CITY OF PORTLAND, MAINE

October 25, 2016

Project Name:	Dirigo Plaza	Project ID:	#2016-073
Address:	1190 Brighton Avenue, Westbrook, Maine	CBL:	264-A-002
Applicant:	Dirigo Center Developers, LLC. (previously J & J Gove Development Group)		
Planner:	Barbara Barhydt, Development Review Services Manager

To: Elizabeth Boepple, Chair, and Members of the Portland Planning Board
From: Barbara Barhydt, Development Review Services Manager
Date: October 14, 2016
Re: Dirigo Plaza (Main Street Westbrook, 1190 Brighton Avenue, Dirigo Center Developers, LLC, Applicant
Project #: 2016-073 **CBL:** 264-A002
Hearing Date: October 18, 2016

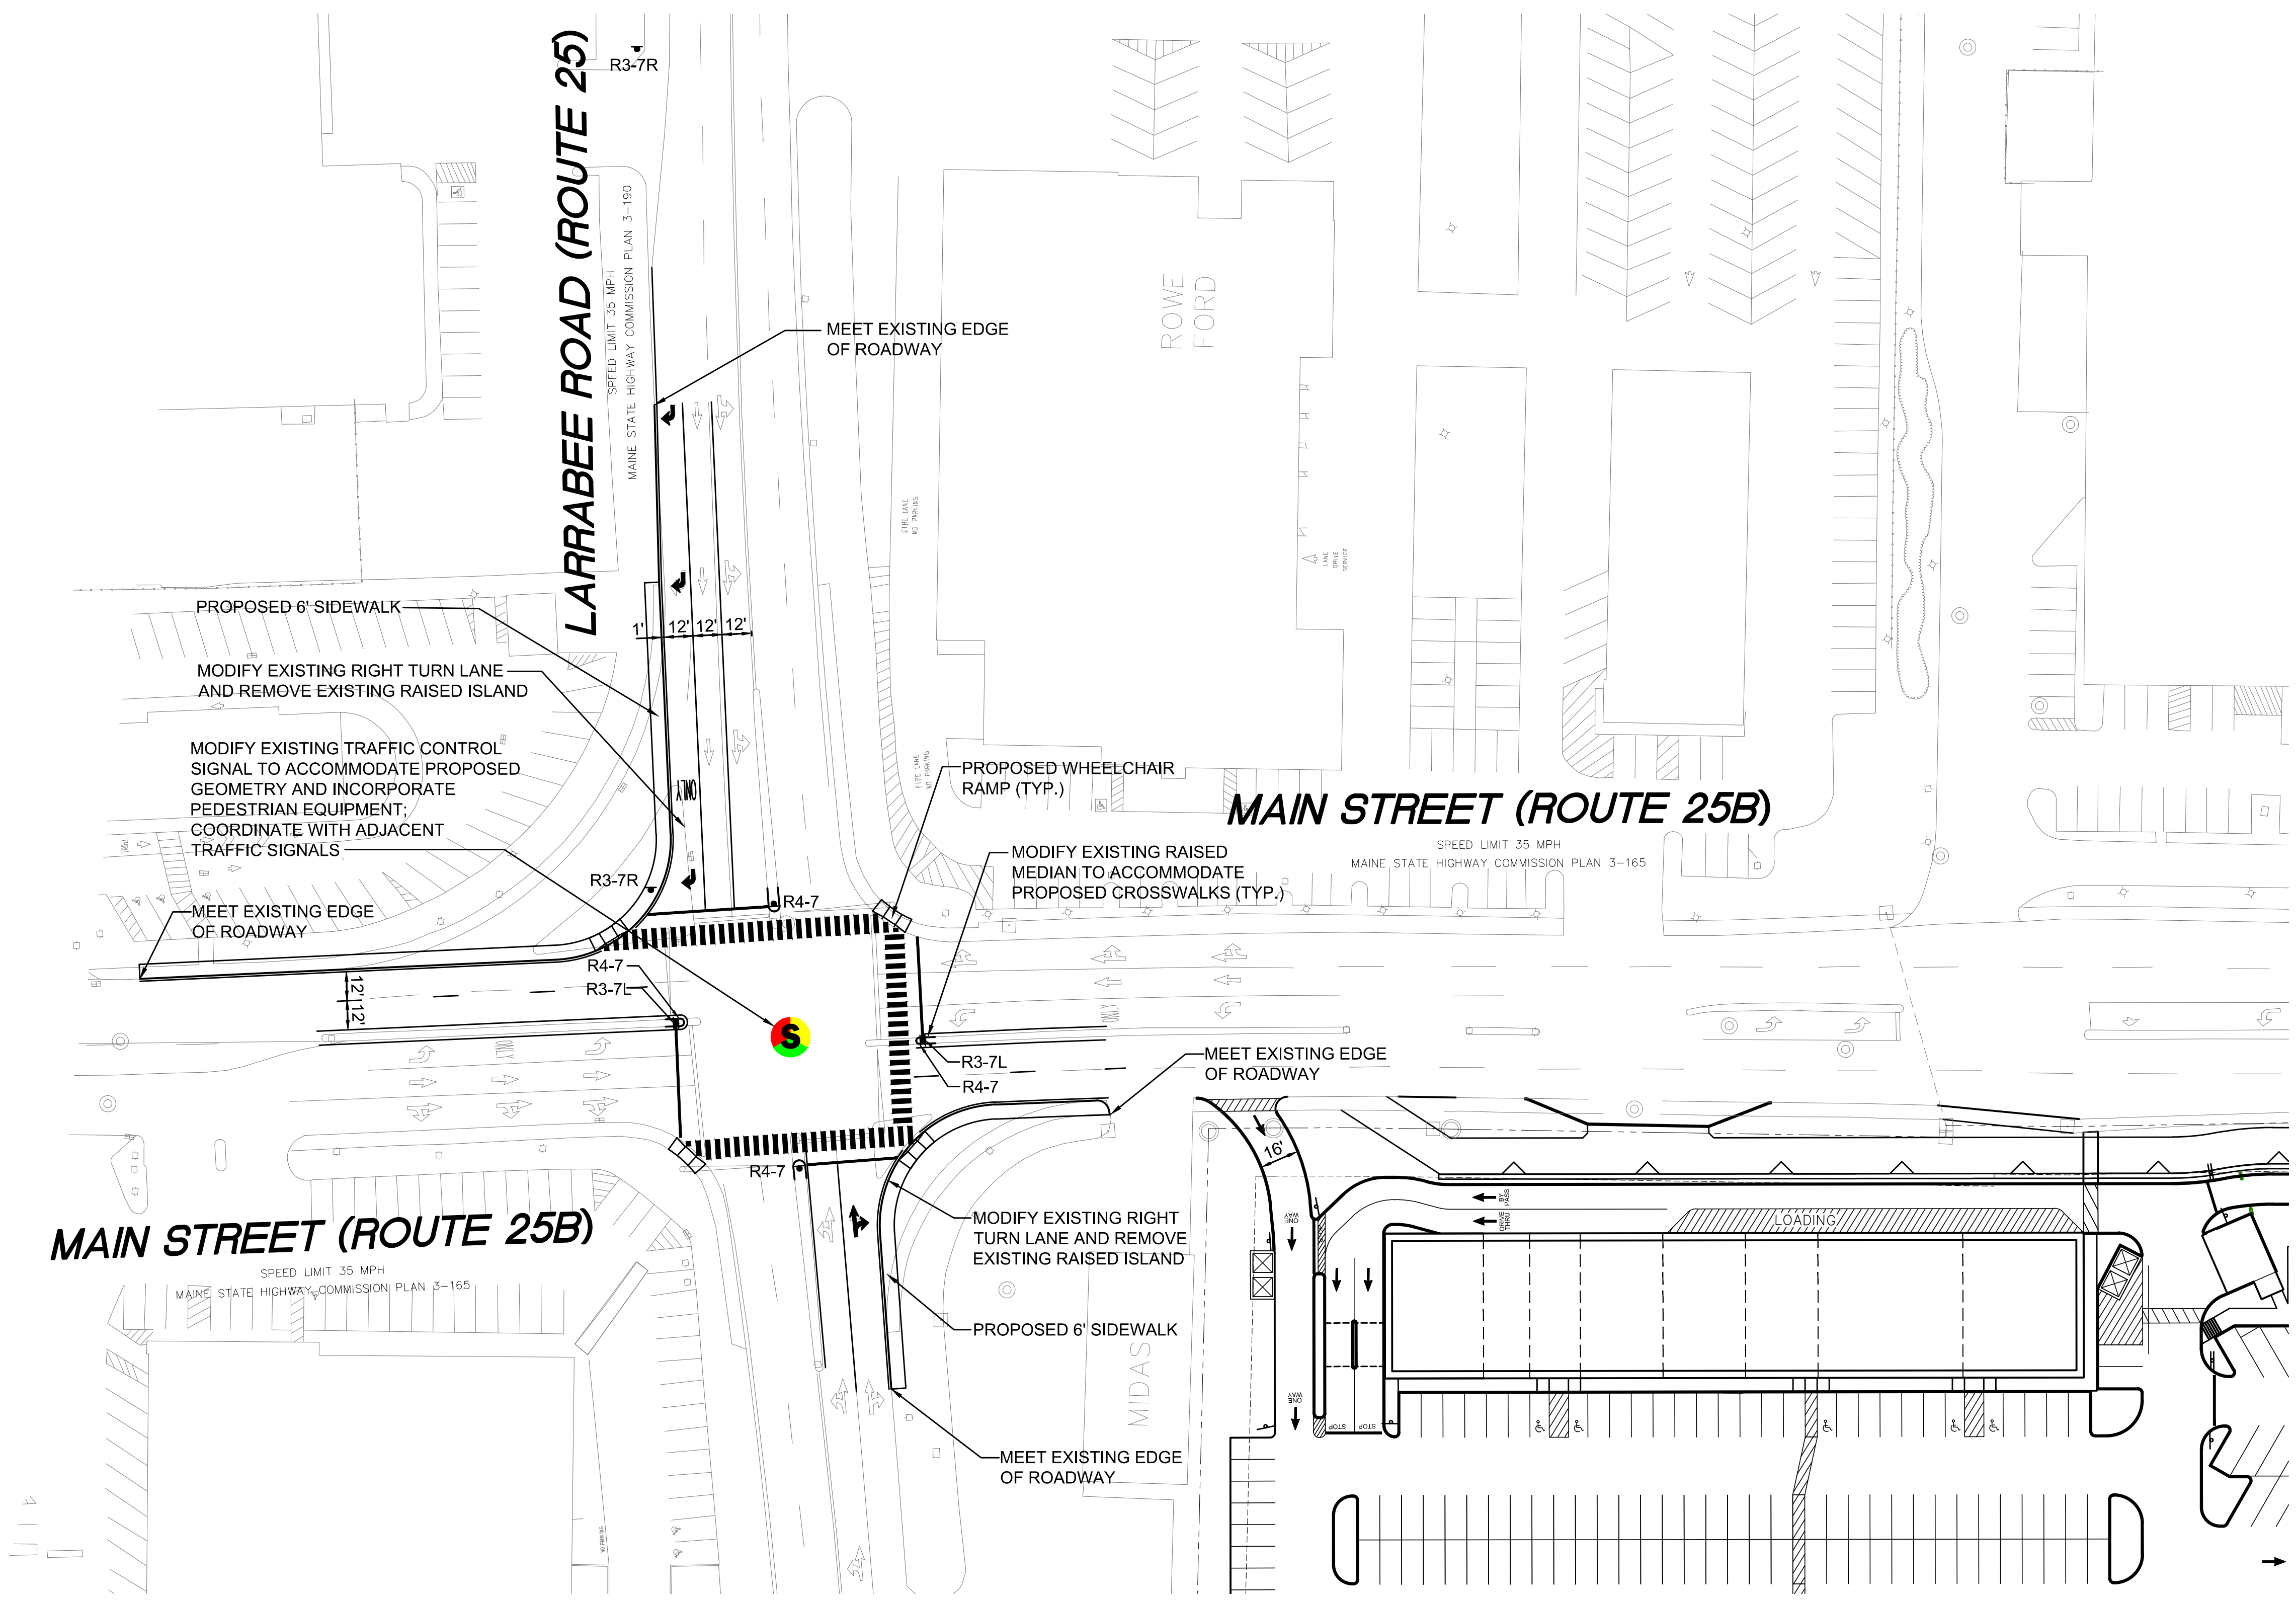
5. Intersection of Riverside St / Brighton Ave / Main St (see Figure 14 Conceptual Improvement Plan, Sheet 4 of 5)

Design and implement an optimal traffic signal timing, phasing and coordination plan. Ensure there is a hardwire interconnect between adjacent intersections.

Portland Staff Comment: In its memo to the Board and its comments on the draft TMP, the applicant has agreed to updated signal heads with reflective back plates (as proposed on the applicant's Conceptual Improvement Plan, Sheet 4 of 5), and updated thermal (not video) detection to meet the City's standard.
